**Project Name: Lot 2/3 Rolling Thunder Business Park**

**Project Number: PPR 2010 and SF 209**

**Description:** Approval is being requesting for Site Development Plan and Final Plat for Lots 2 and 3 of Rolling Thunder Business Park for a commercial building for retail or general office use. These lots are located south of East Woodmen Road and east of Golden Sage Road in Section 11, Township 13S, Range 65W.

ROLLING THUNDER BUSINESS PARK FILING NO. 2

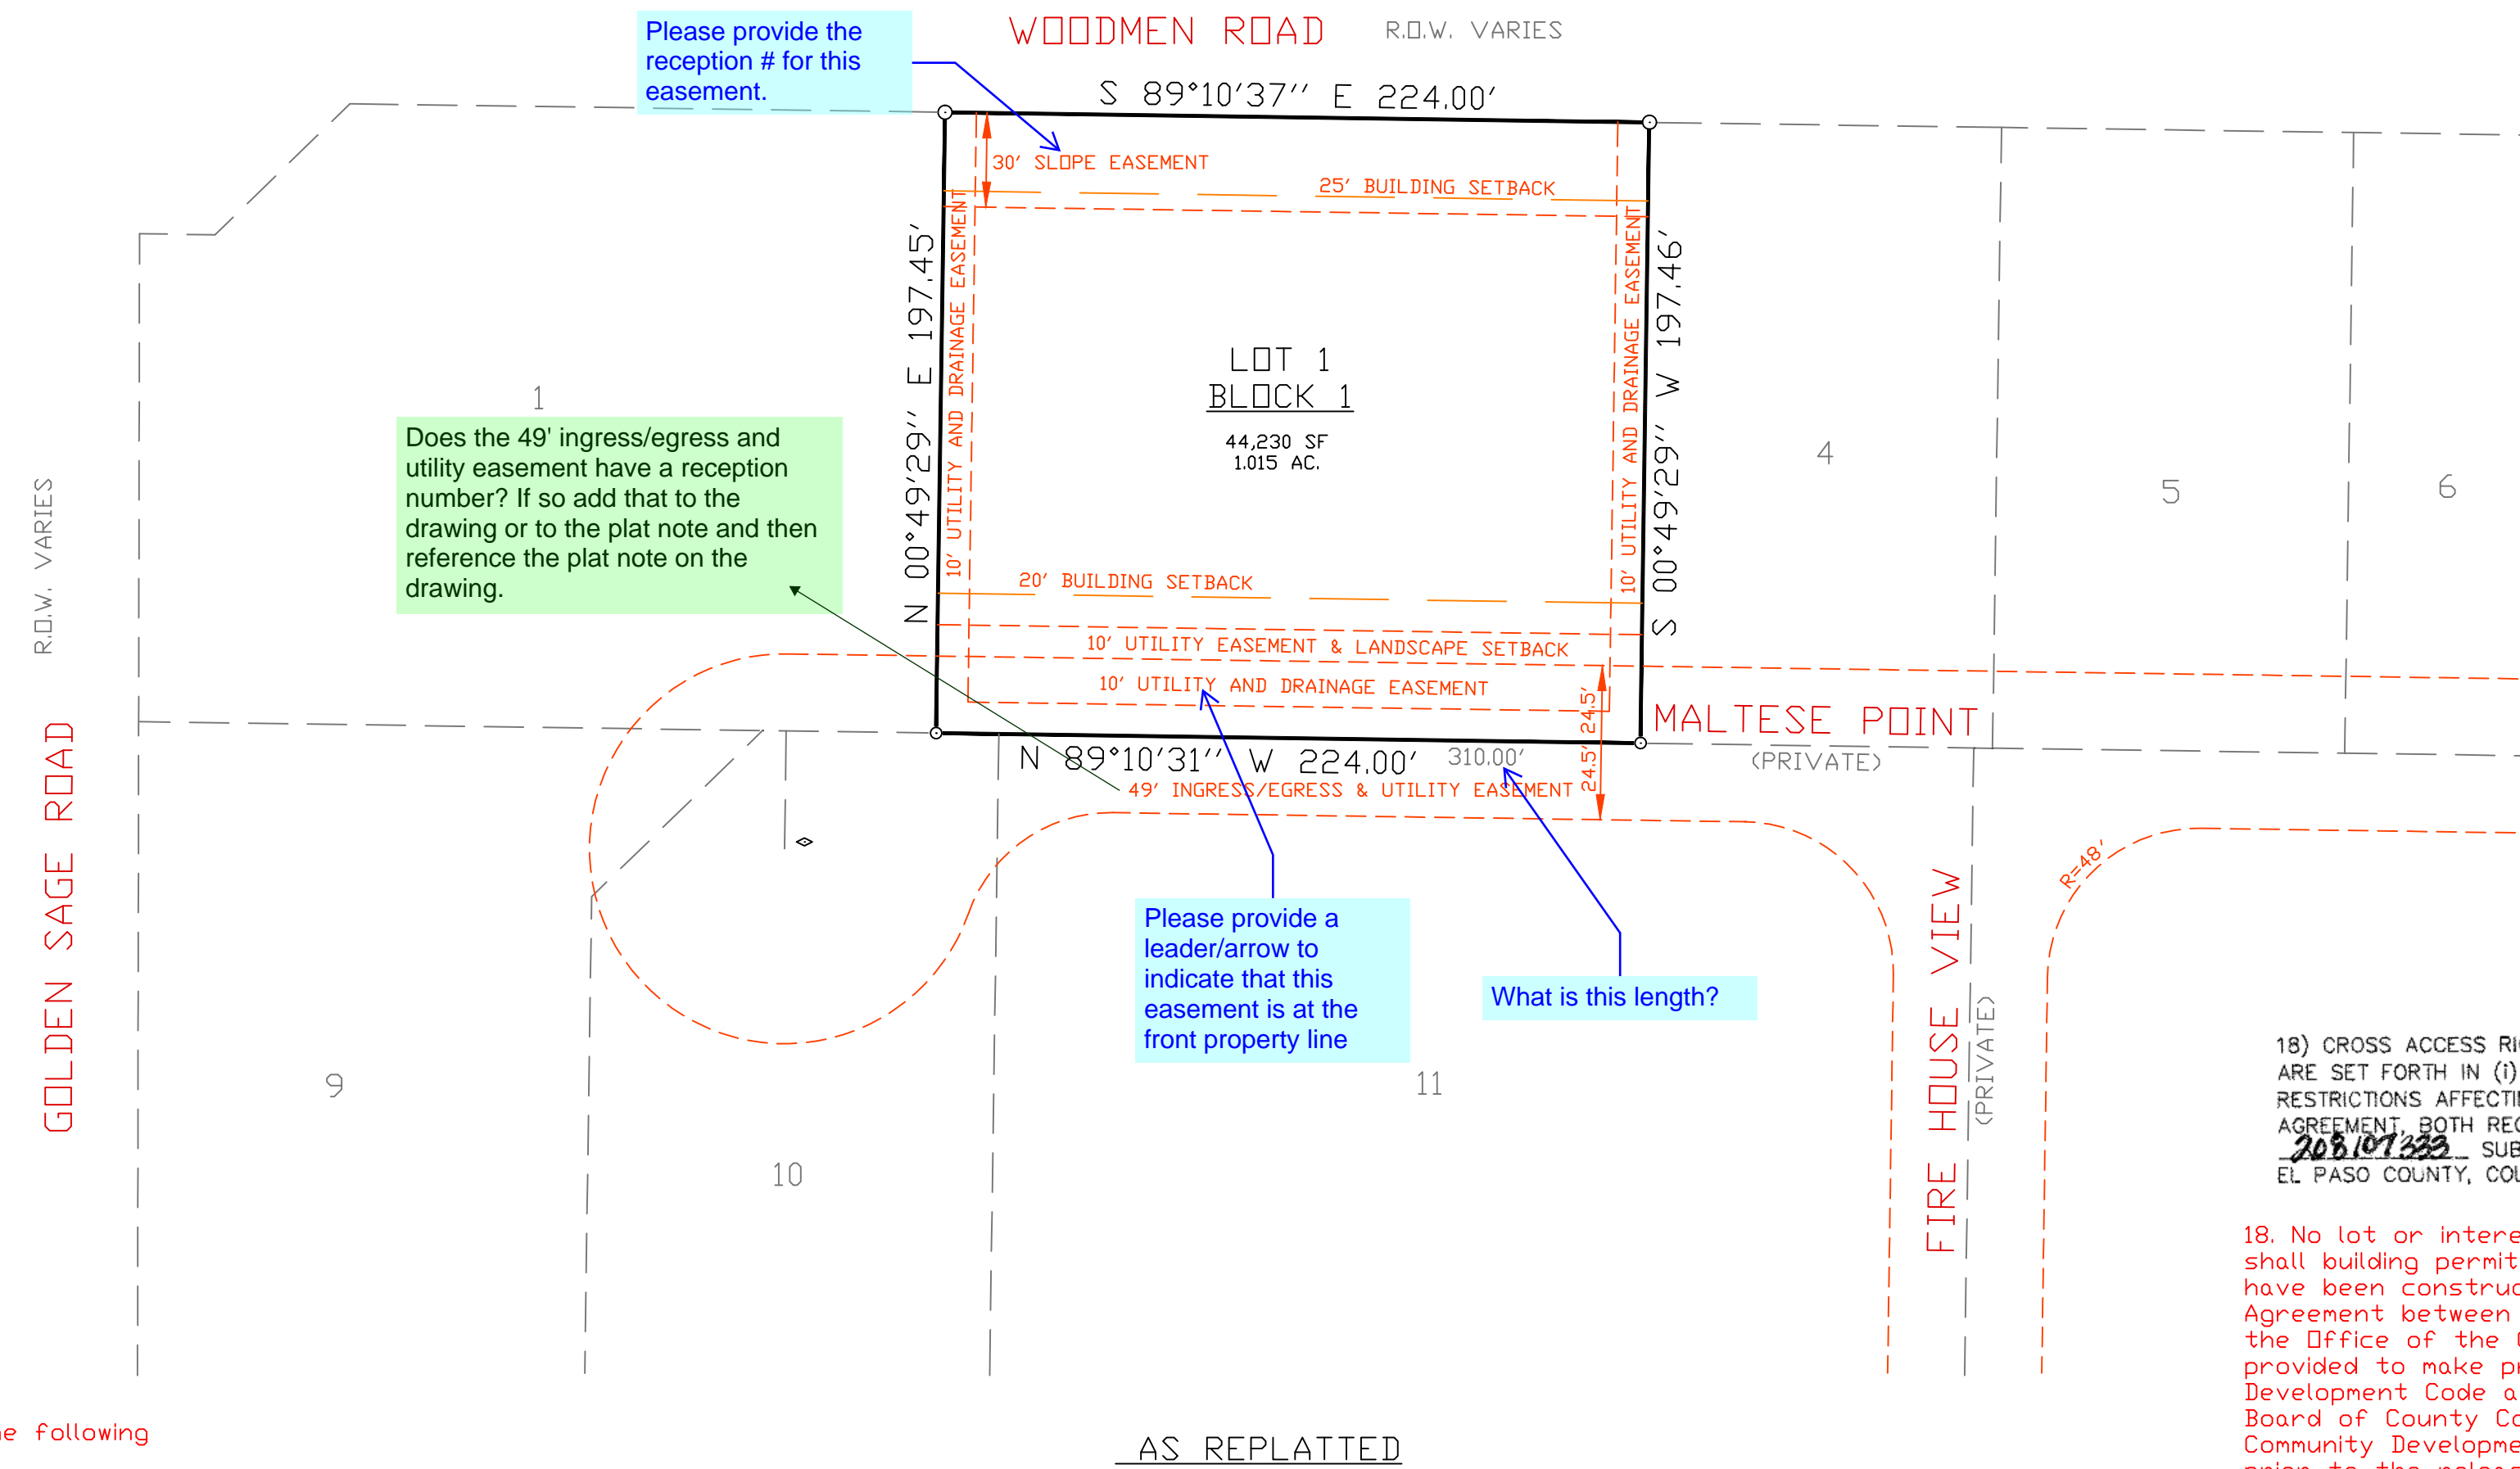
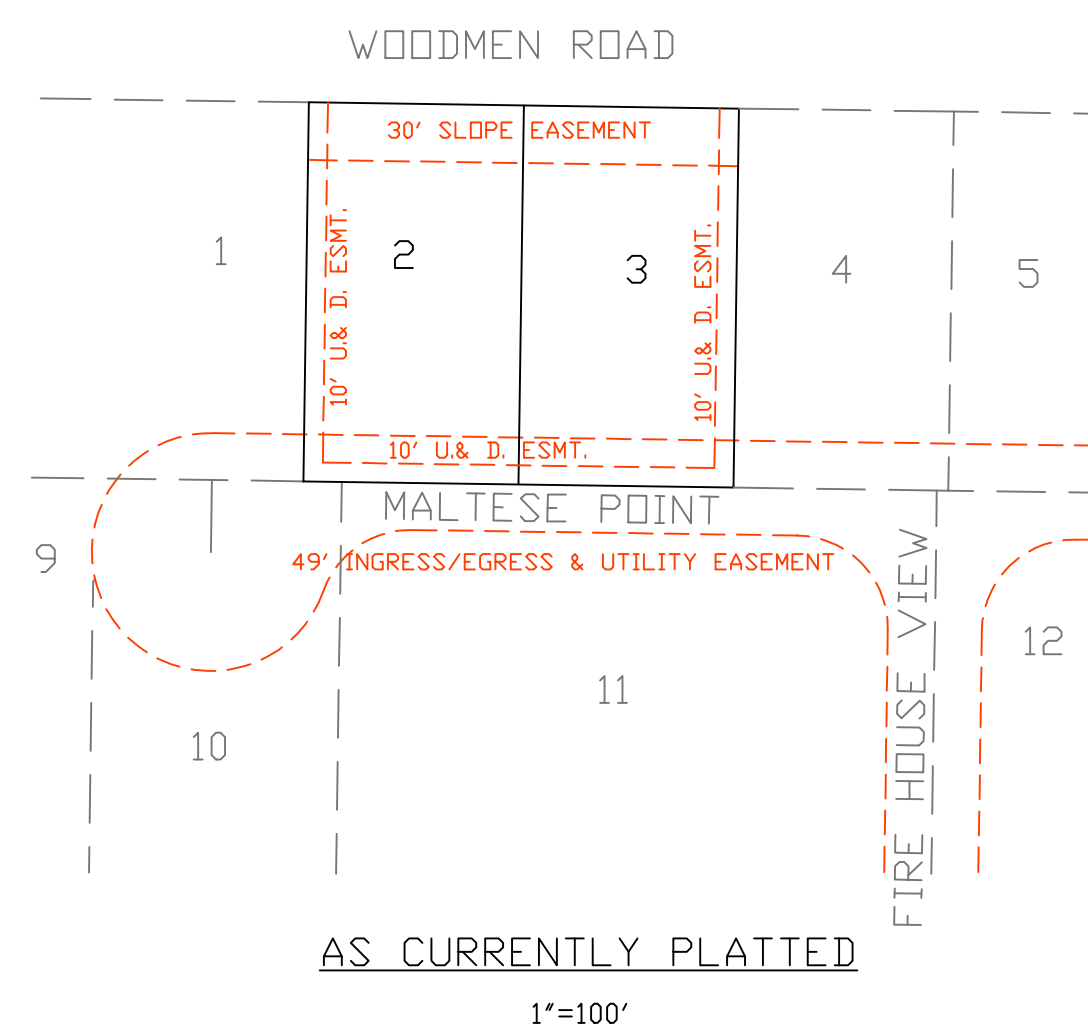
MVEA has designed and build the electrical facilities in this subdivision according to the recorded final plat of Rolling Thunder Business Park. By vacating the side lot line of Lots 2 and 3 the electric facilities may no longer be located on the common side lot line. This lot line adjustment could leave facilities such as pedestals and transformers in an inconvenient location. If there is any removal or relocation of facilities to accommodate the redesign it will be at the expense of the applicant.
